From: Simon Davis
Sent: 28 November 2018 10:53
To: 'Critchley Architecture and Design'
Cc: Elvin Gomery; Alex Eggett
Subject: RE: P/107/18/DOC 7 Webb Close

Ecology comment (condition 14)

Drainage comment (condition 3)

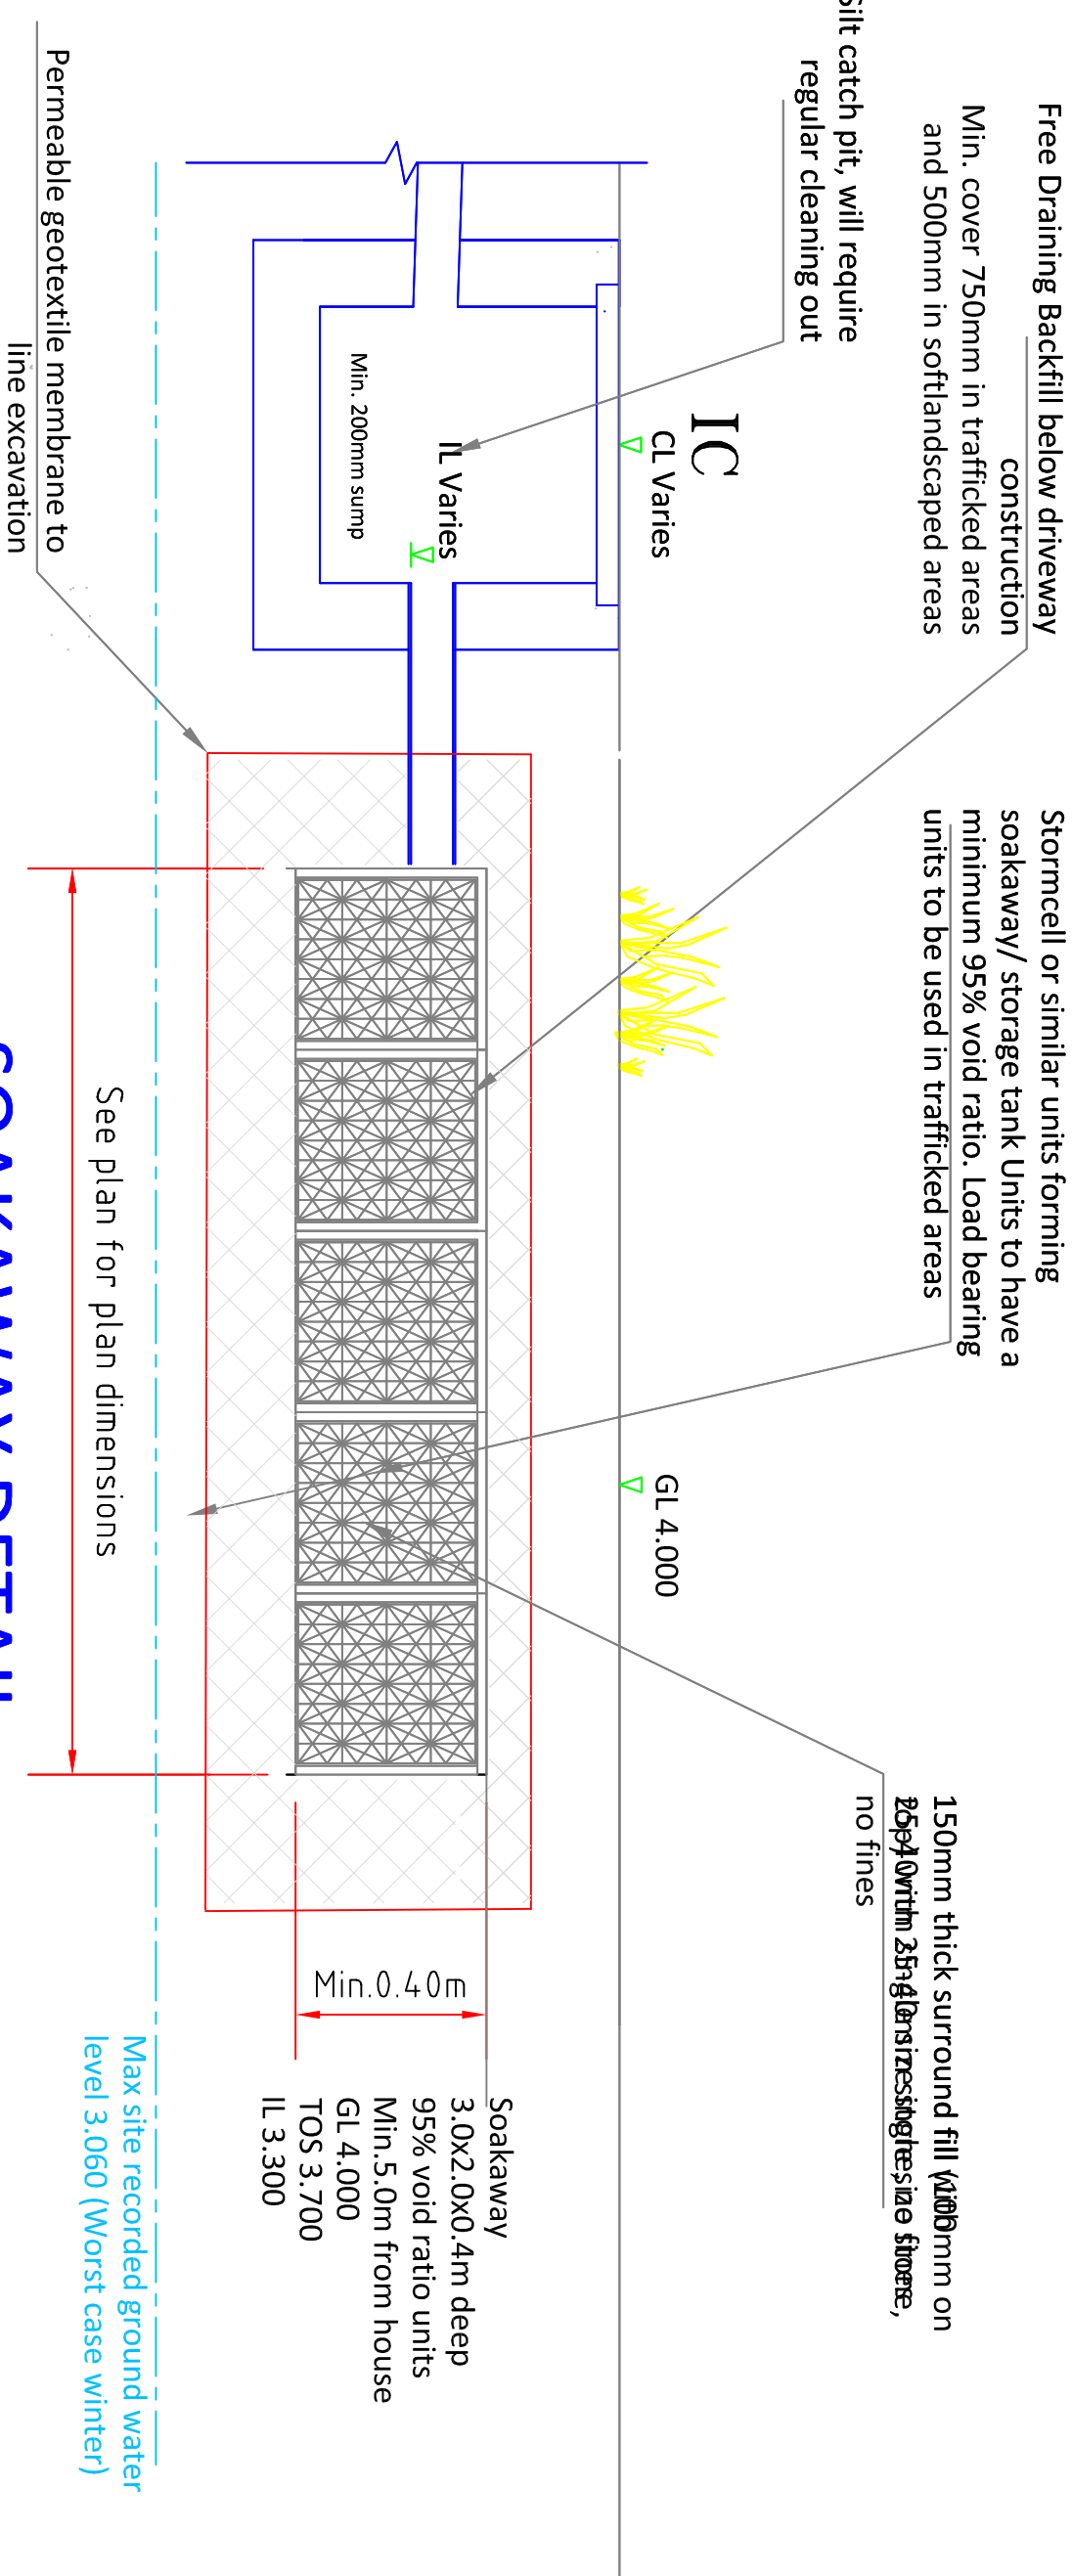
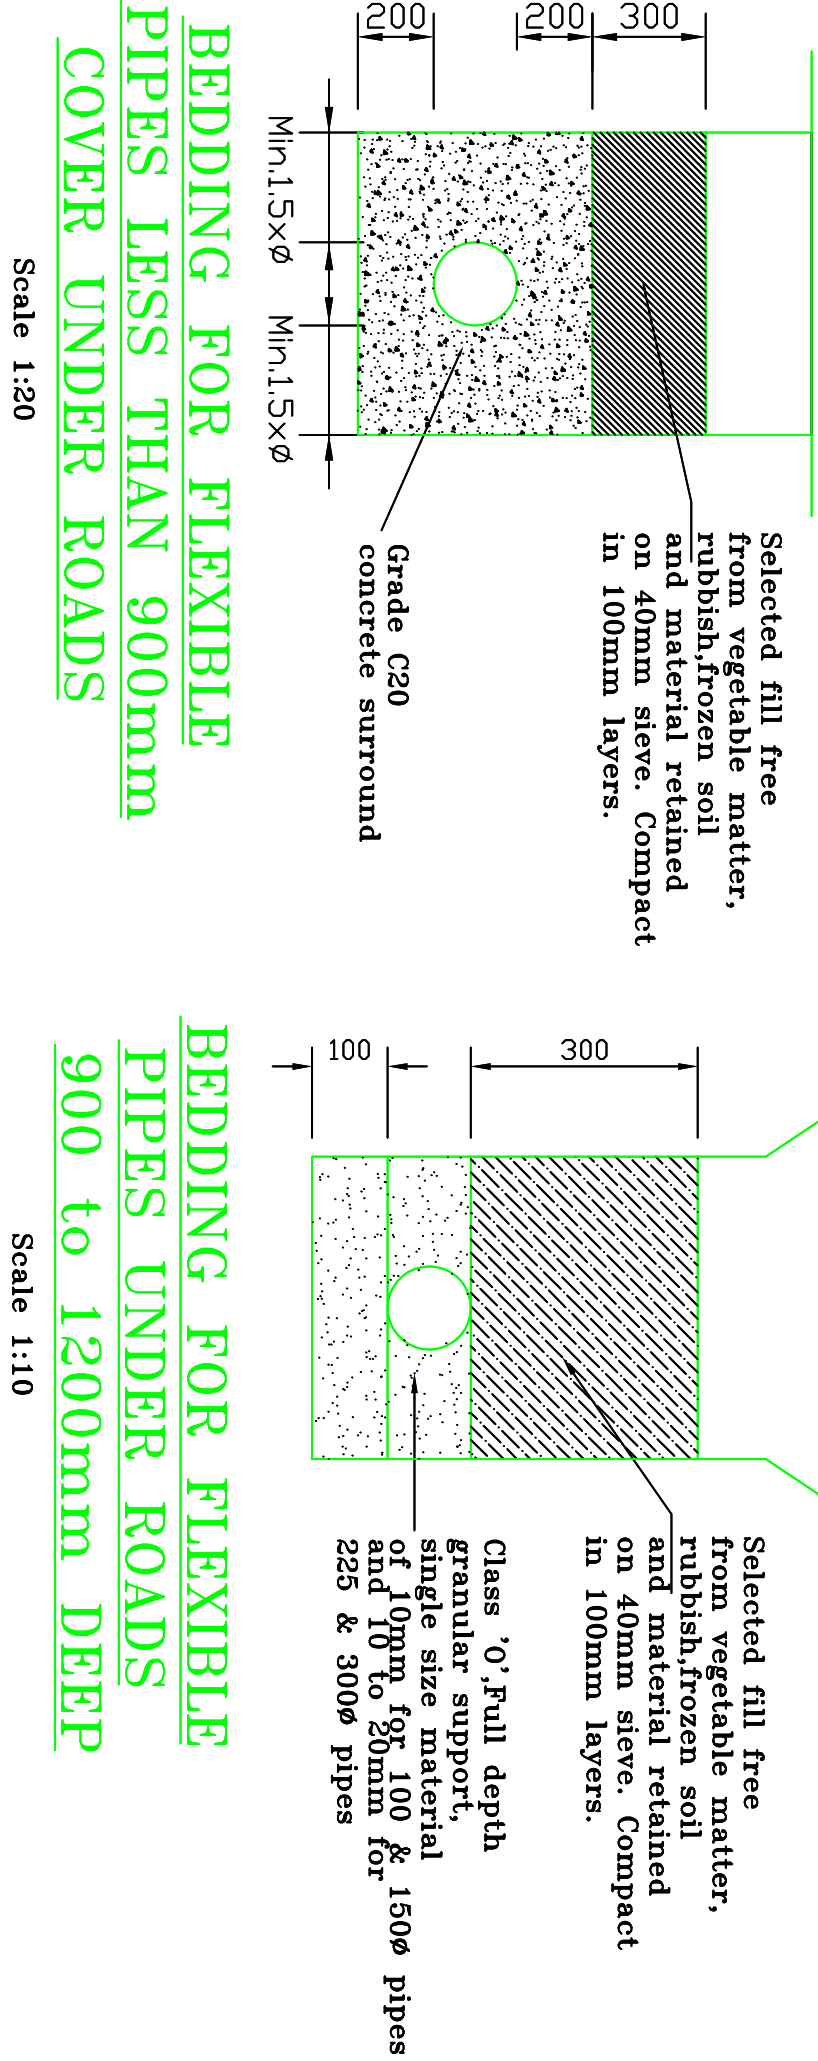
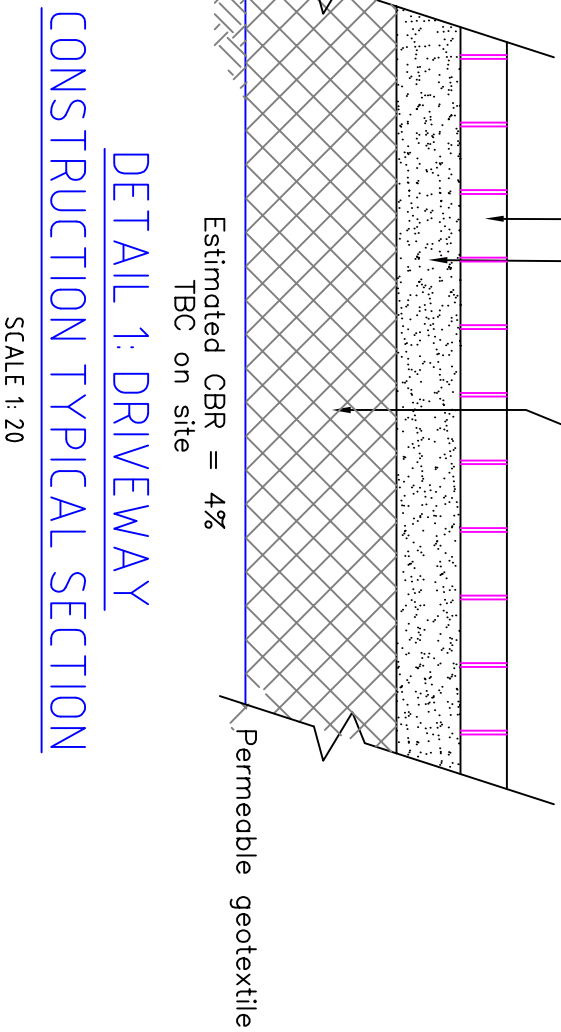
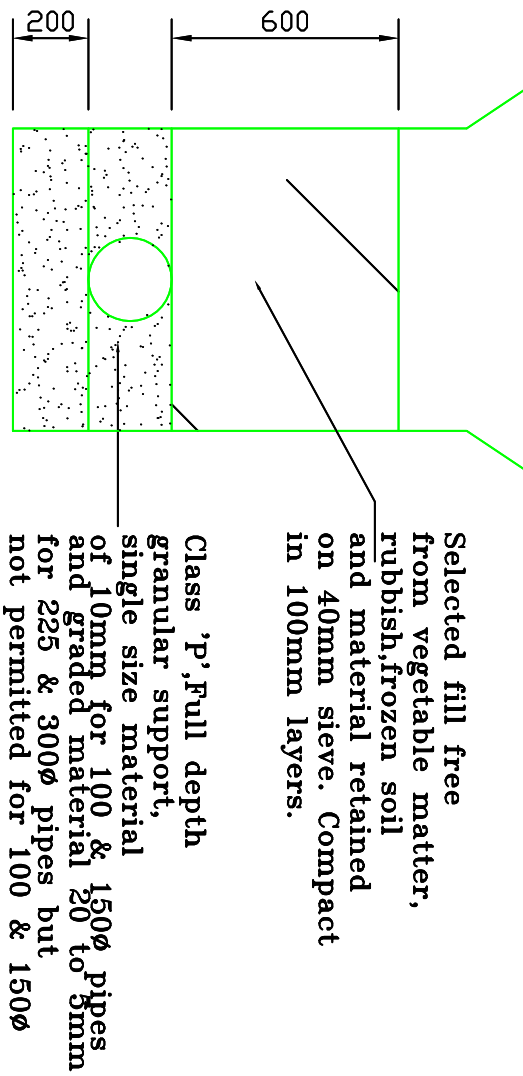
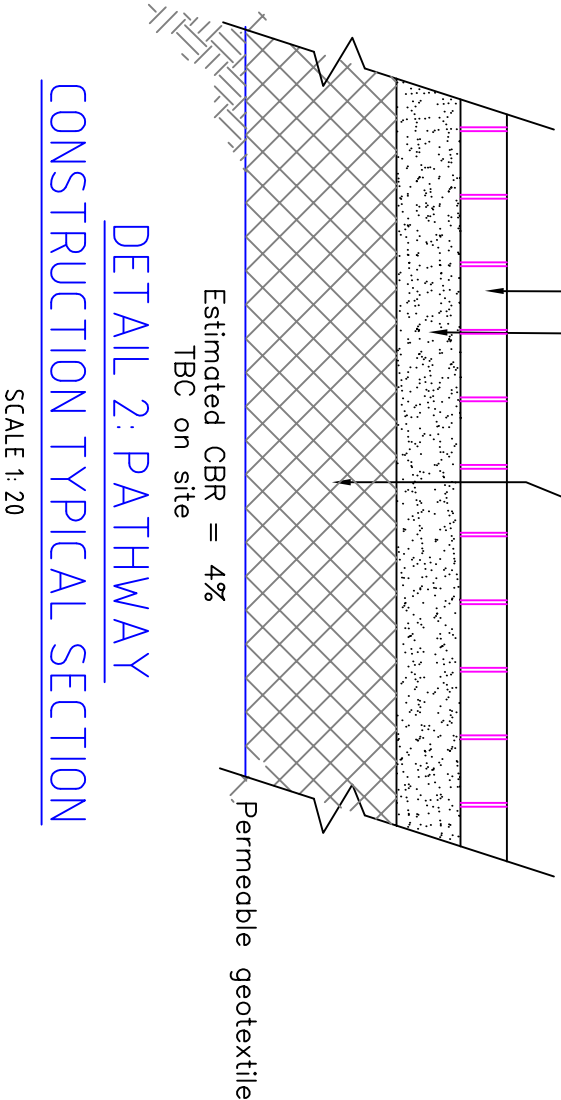
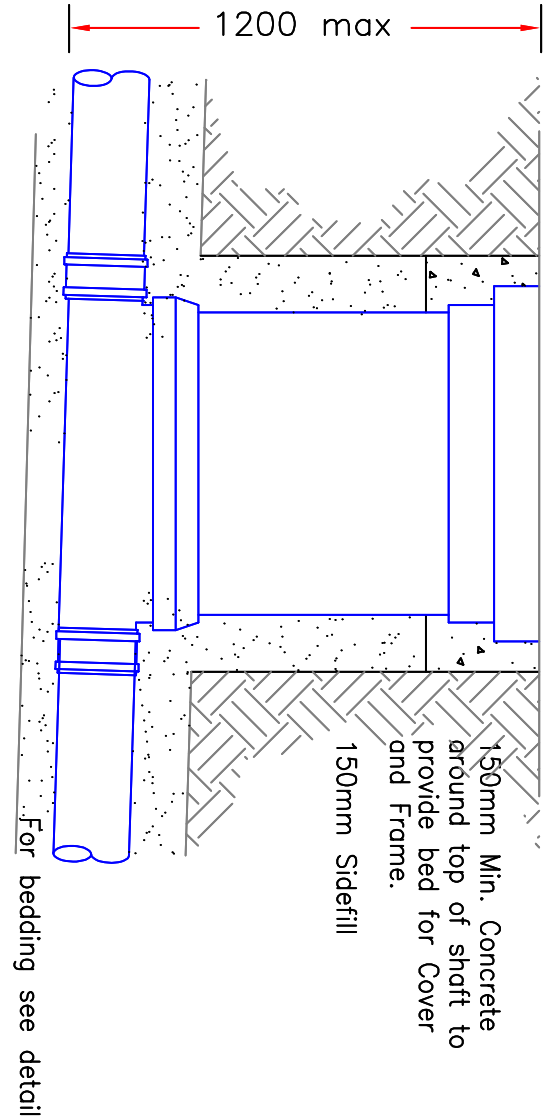
“The construction detail drawings provided demonstrate that there is an issue with the surface water drainage design. The soakaway crates proposed require a cover depth of 500mm in soft landscaped areas and 750mm in trafficked areas. Yet only 0.3m cover depth is proposed. Please specify stronger crates or alternative cover arrangements.”

The details for this were provided by a specialist firm, we are forwarding your comments to them.

Biard Le Mans Up or Down Outdoor Wall Light

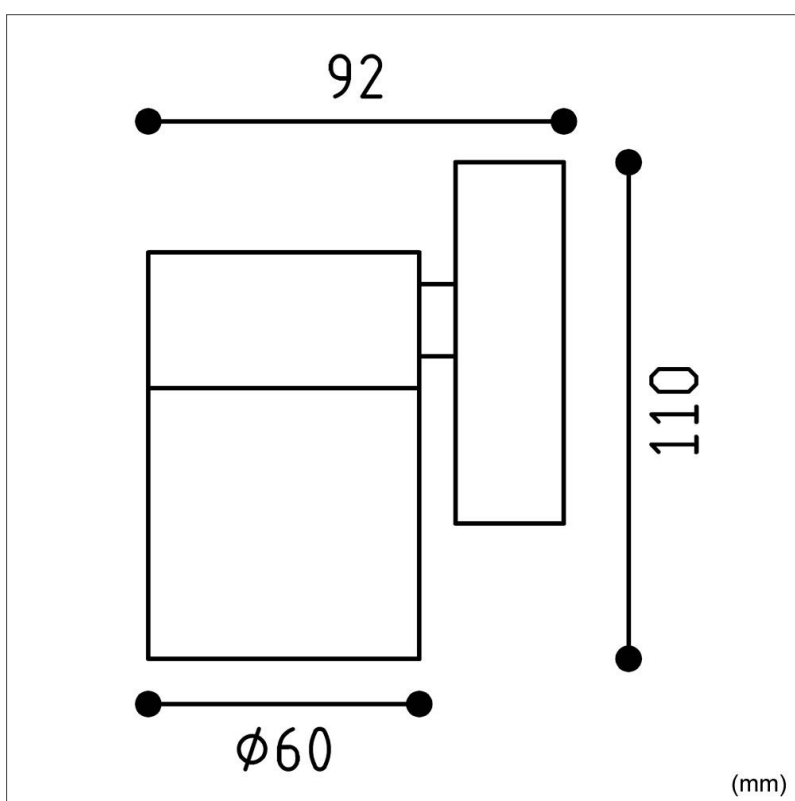
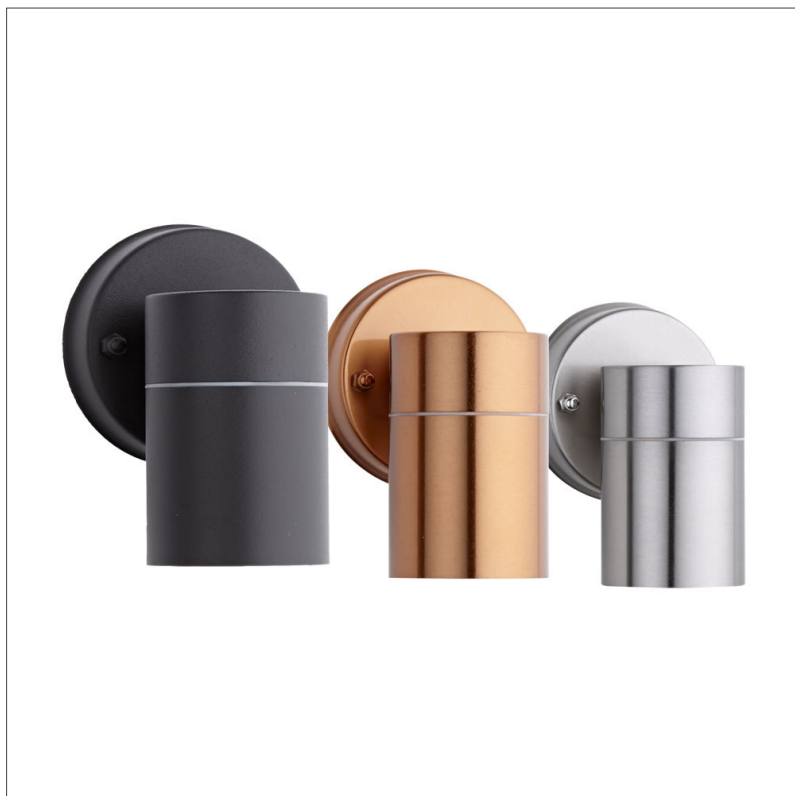
Thanks for the email. I have looked at the lighting spec and note the reference to up or down. Does that mean that once fitted in the down position, a future resident can simply turn the light 180 degrees to make it an up light? Is there some way it can be permanently fixed into being a down light or is there another model that can be used which it is simply a down light?

“The lighting details which have been provide include lights which can be used for up or down directional lighting. We require that only down lighting is used for the scheme, so the lights will need to be installed to only provide downward lighting.”

We are happy to agree that the lights be installed in such a way that they only provide downward illumination, as per the submitted images. They would, after all, not be very useful as pathway lighting if they pointed upwards.
